# Charlotte Department of Transportation

## Memorandum

**Date:** March 6, 2008

**Subject:** Rezoning Petition 08-059: Located on the east side of the I-85 and City Boulevard Interchange

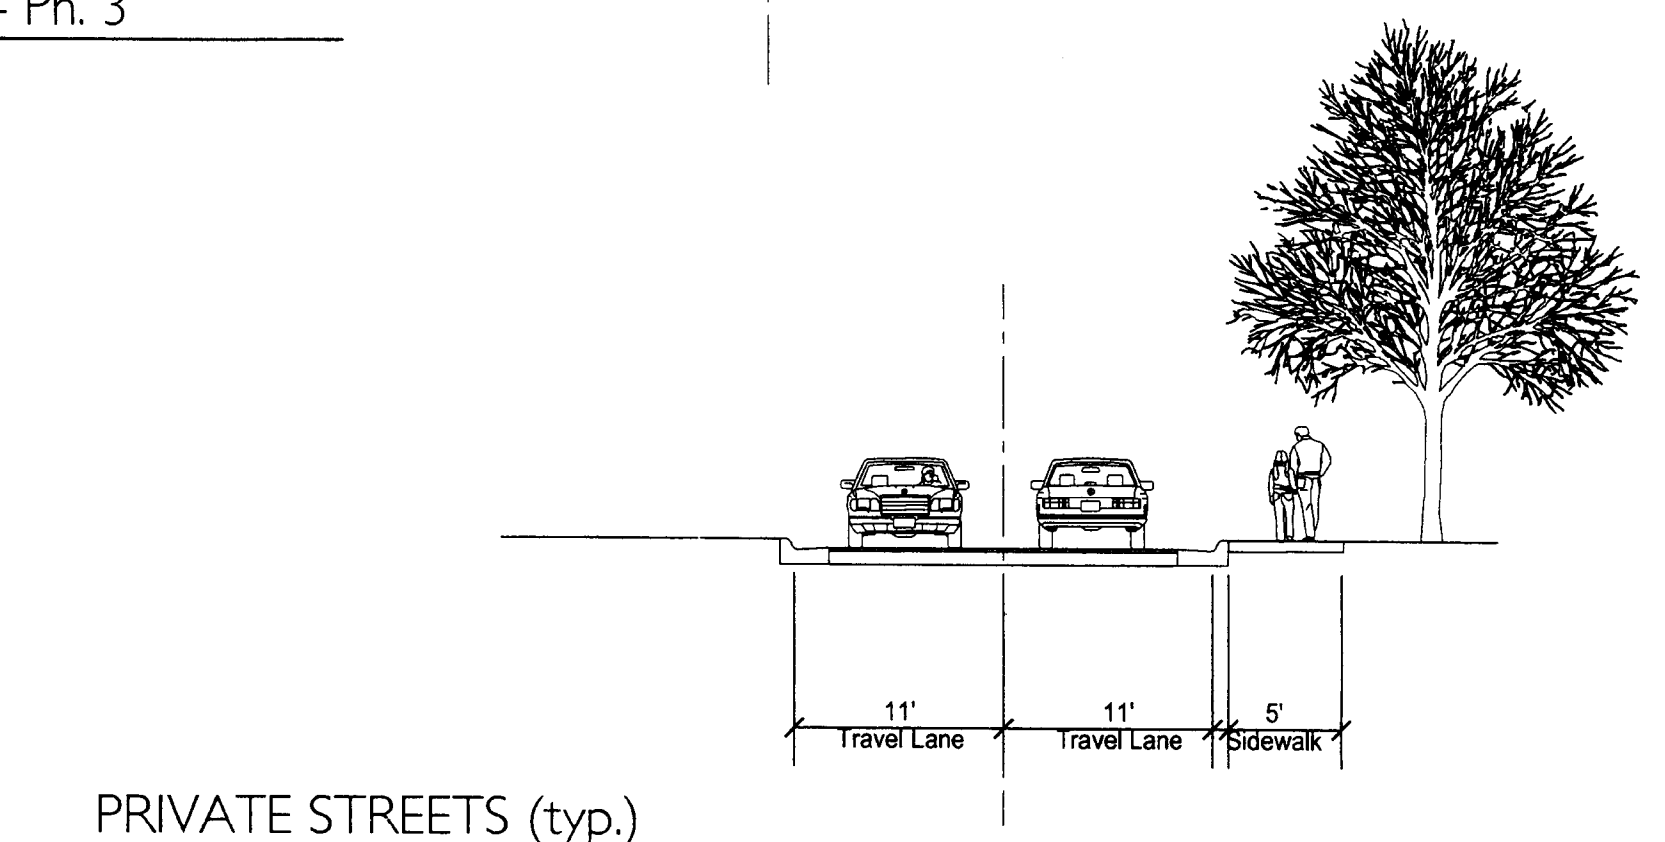
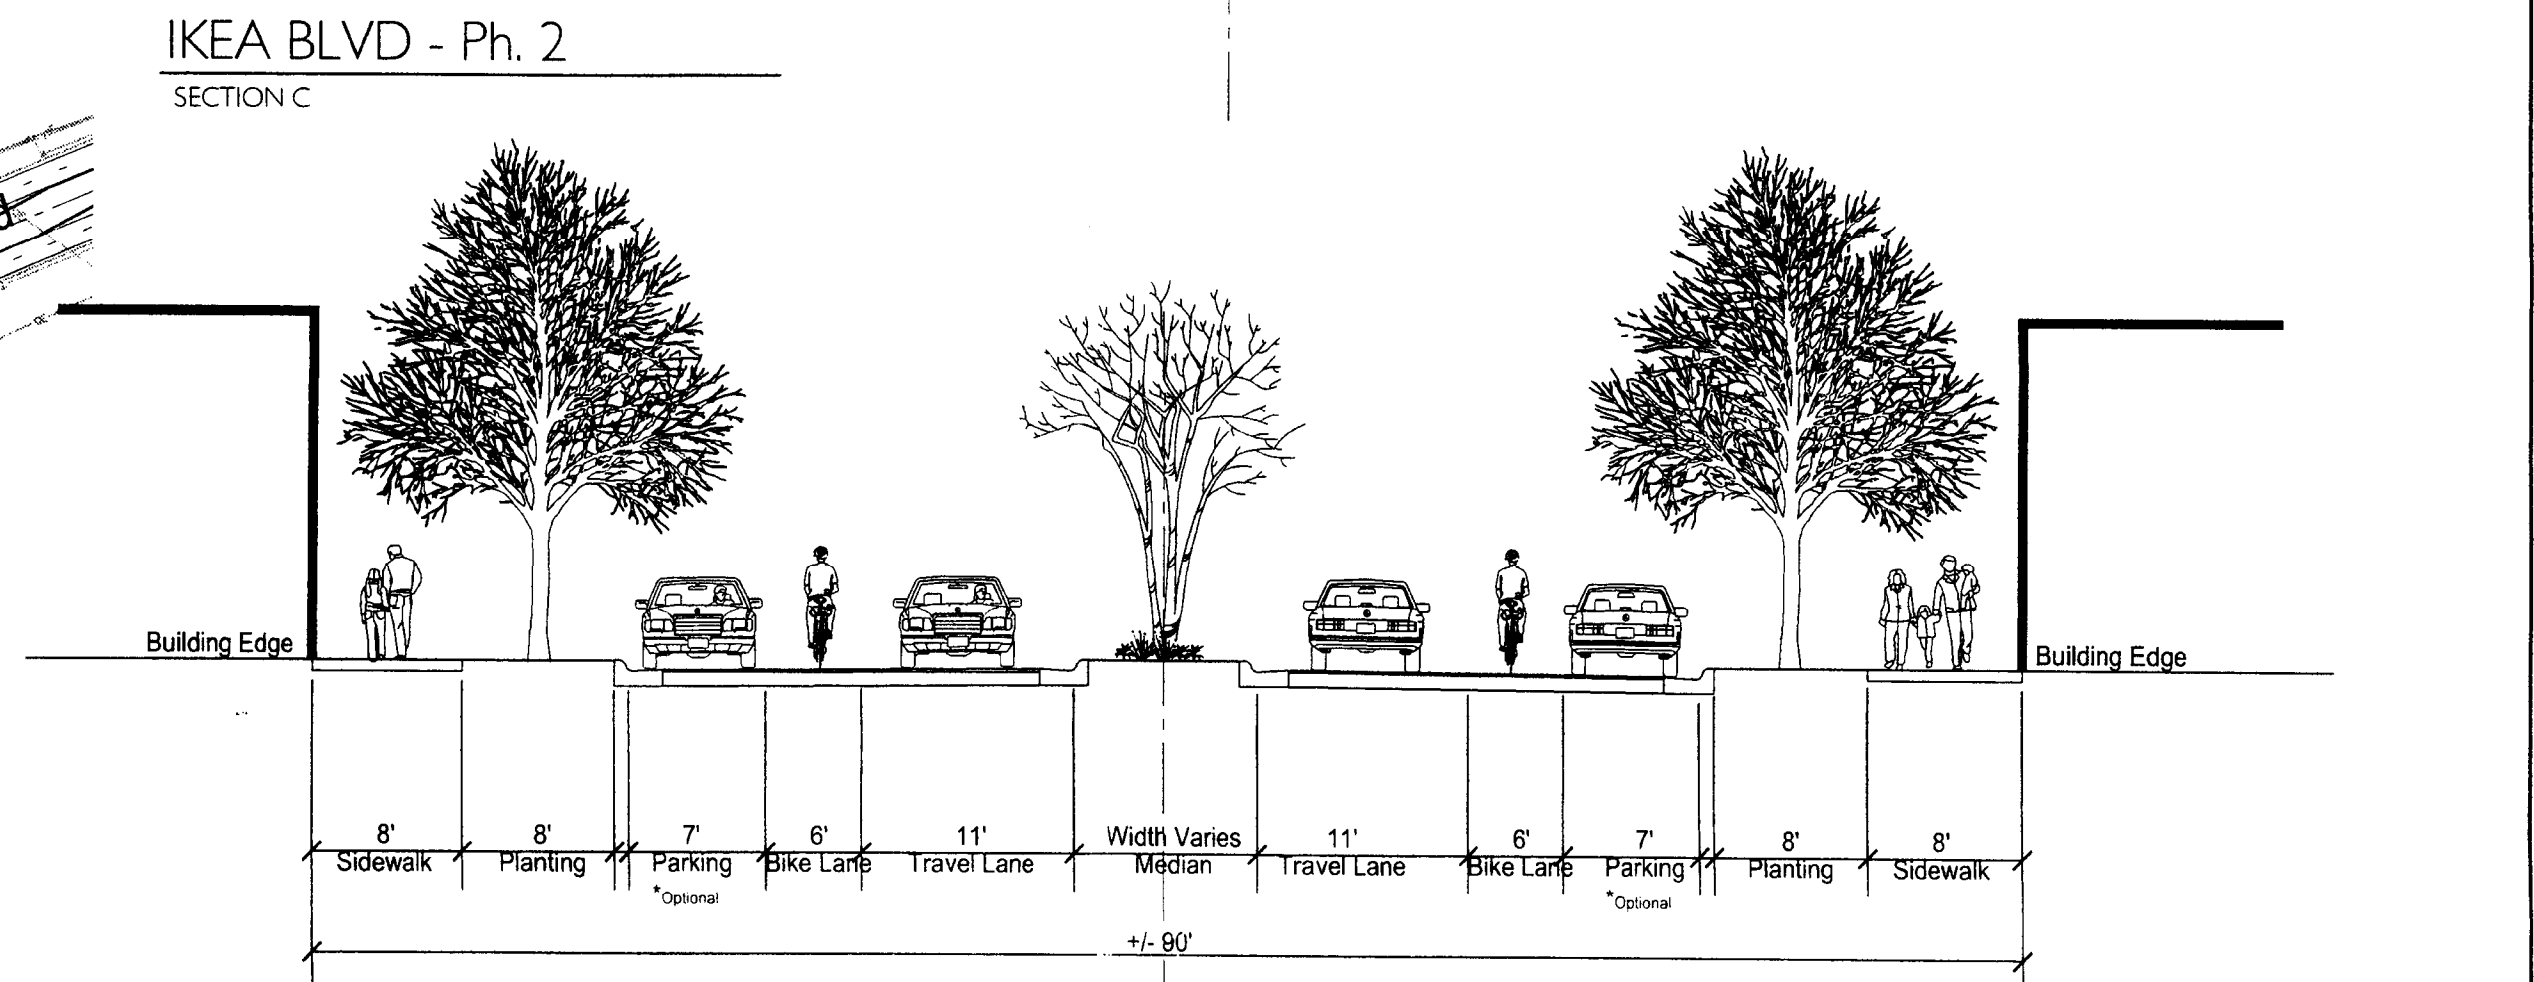
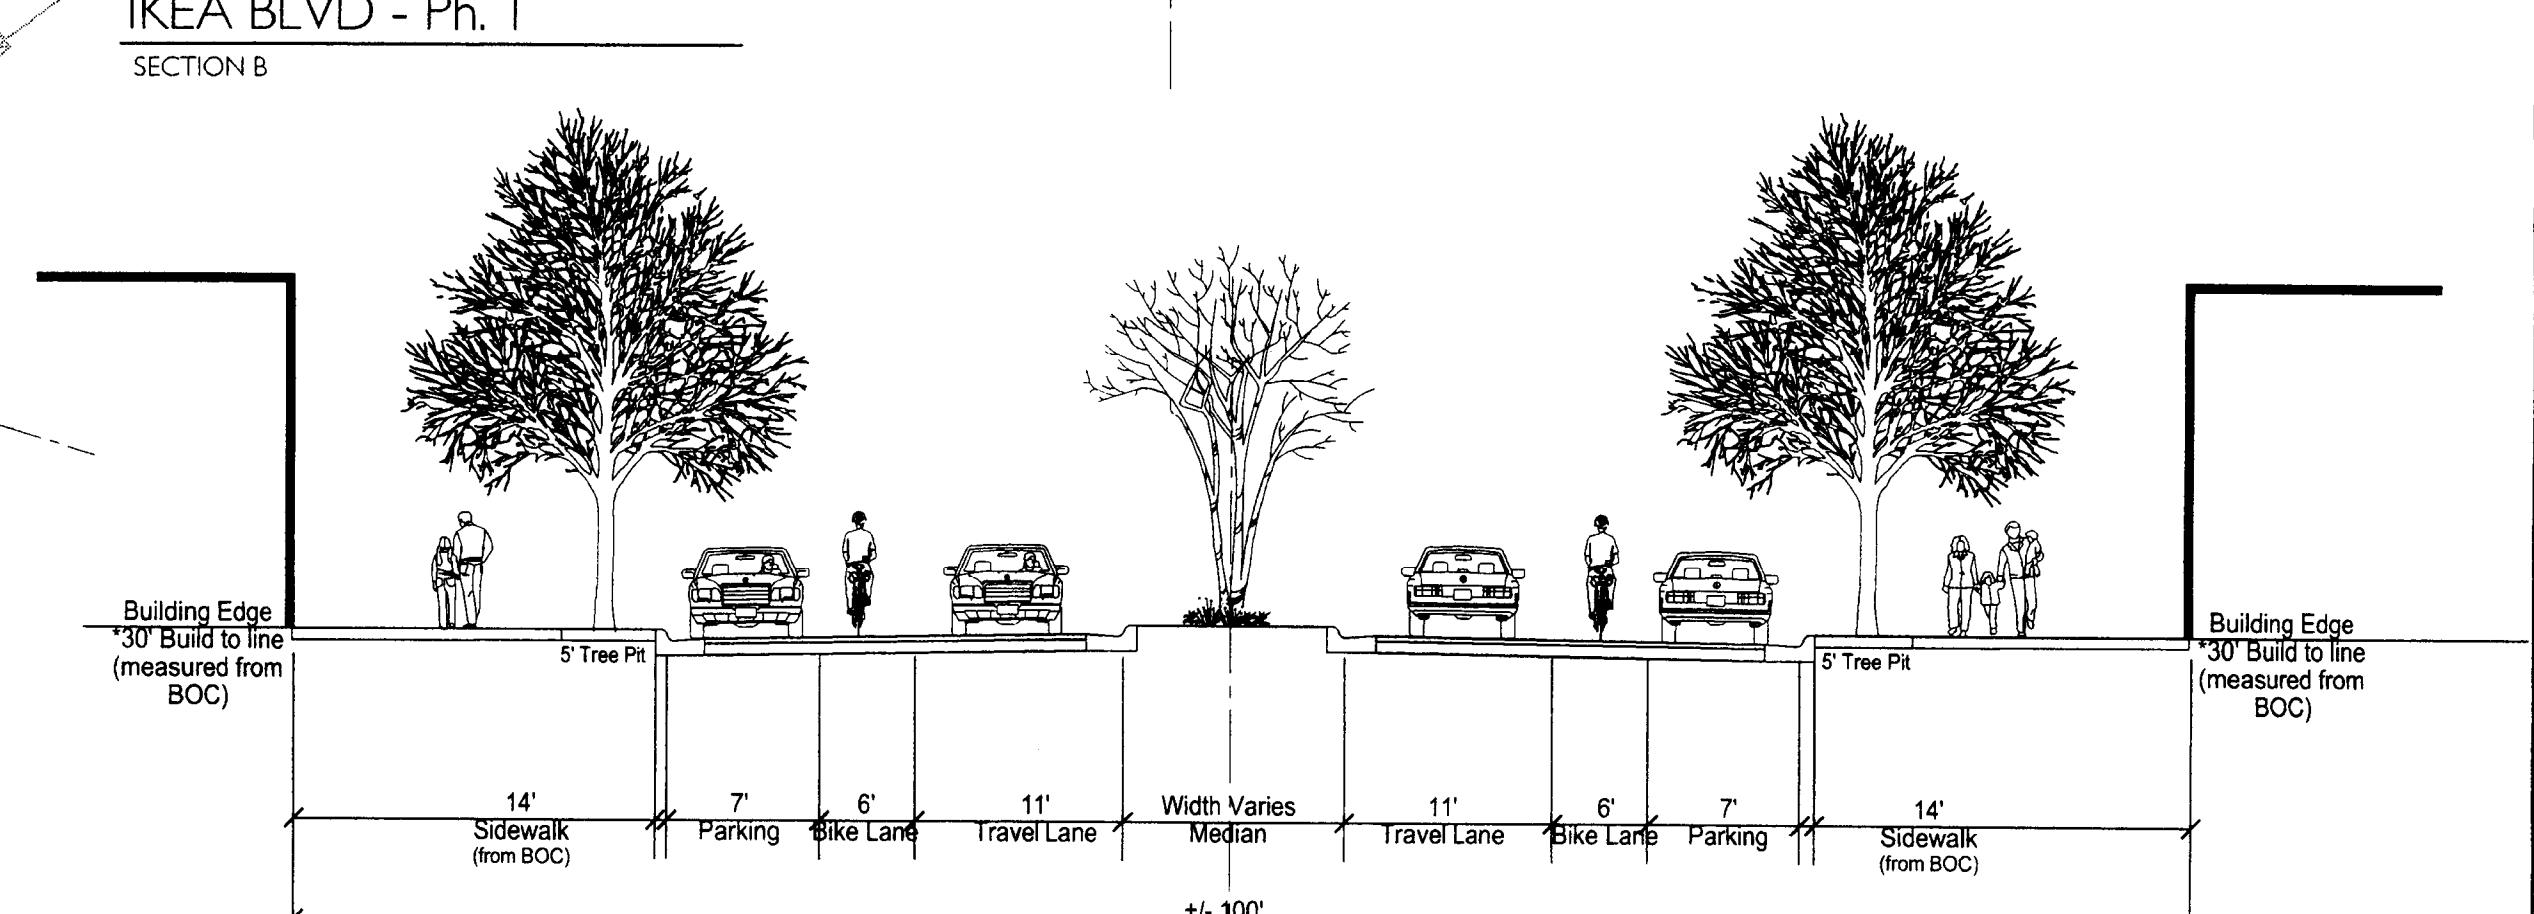
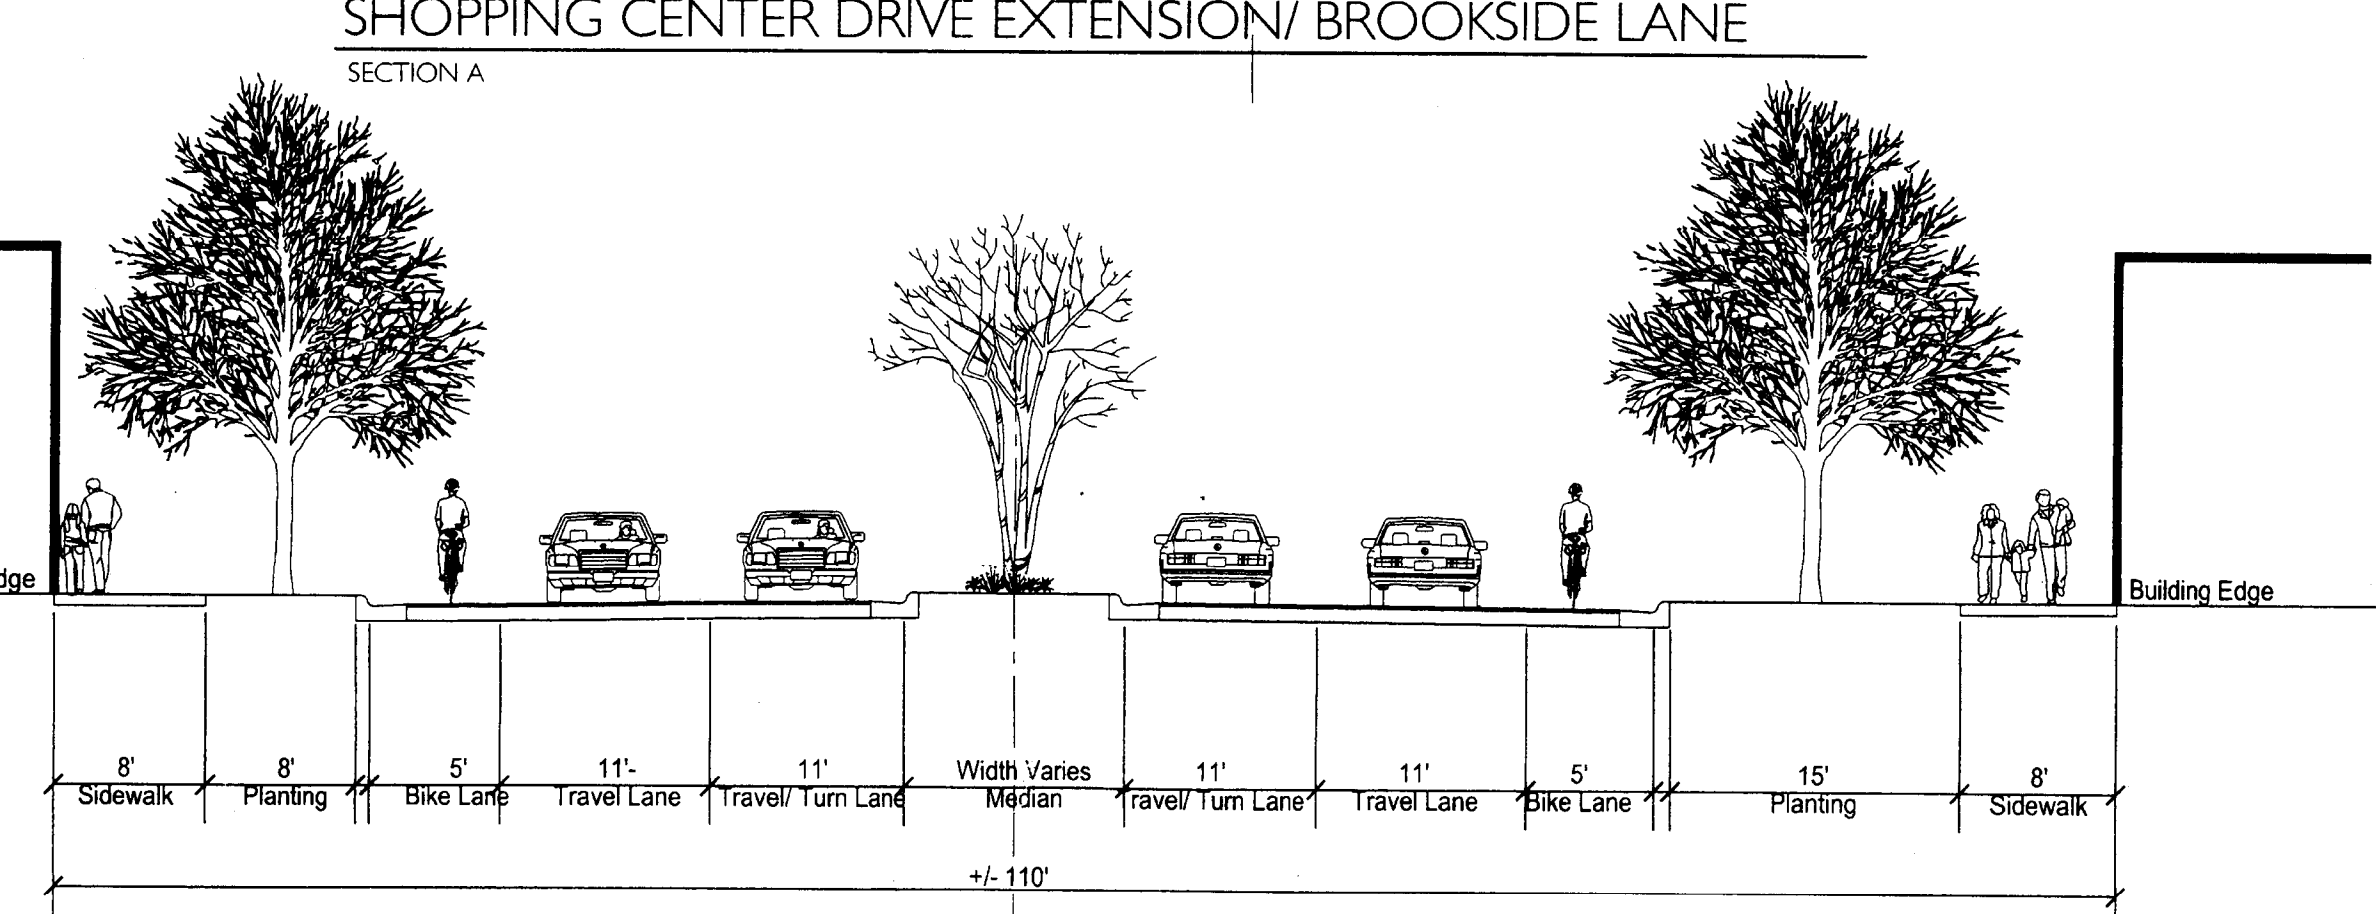
7. The middle portion of IKEA Boulevard (from IKEA to Shopping Center Drive) is classified as an Avenue (Urban Street Design Guidelines, USDG). Cross-sections C-C and D-D need to reflect this. Due to the intensity of proposed development and the mix of land uses, 8-foot sidewalks need to be provided along IKEA Boulevard. All other local streets/cross sections will need to conform to the appropriate USDG street type.

10. All street dimensions, such as lane widths or parking bay widths, on sections A-A, B-B, C-C, and D-D need to be referenced to the face of curb instead of the back of curb.

1. Because it is a Main Street, Section C-C of Ikea Boulevard should use hardscape, with trees in tree pits, instead of a dedicated planting strip.
2. This project is located within ¼ mile of transit service. However, such a dramatic increase in employment, households and services would likely require a reconfiguration of transit to adequately serve such a significant increase in demand. This project is also located within ¼ mile of two planned transit stations on North Tryon Street (City Boulevard and Rocky River stations). The additional street connections described above will better facilitate multimodal access between the future stations and the various proposed uses.
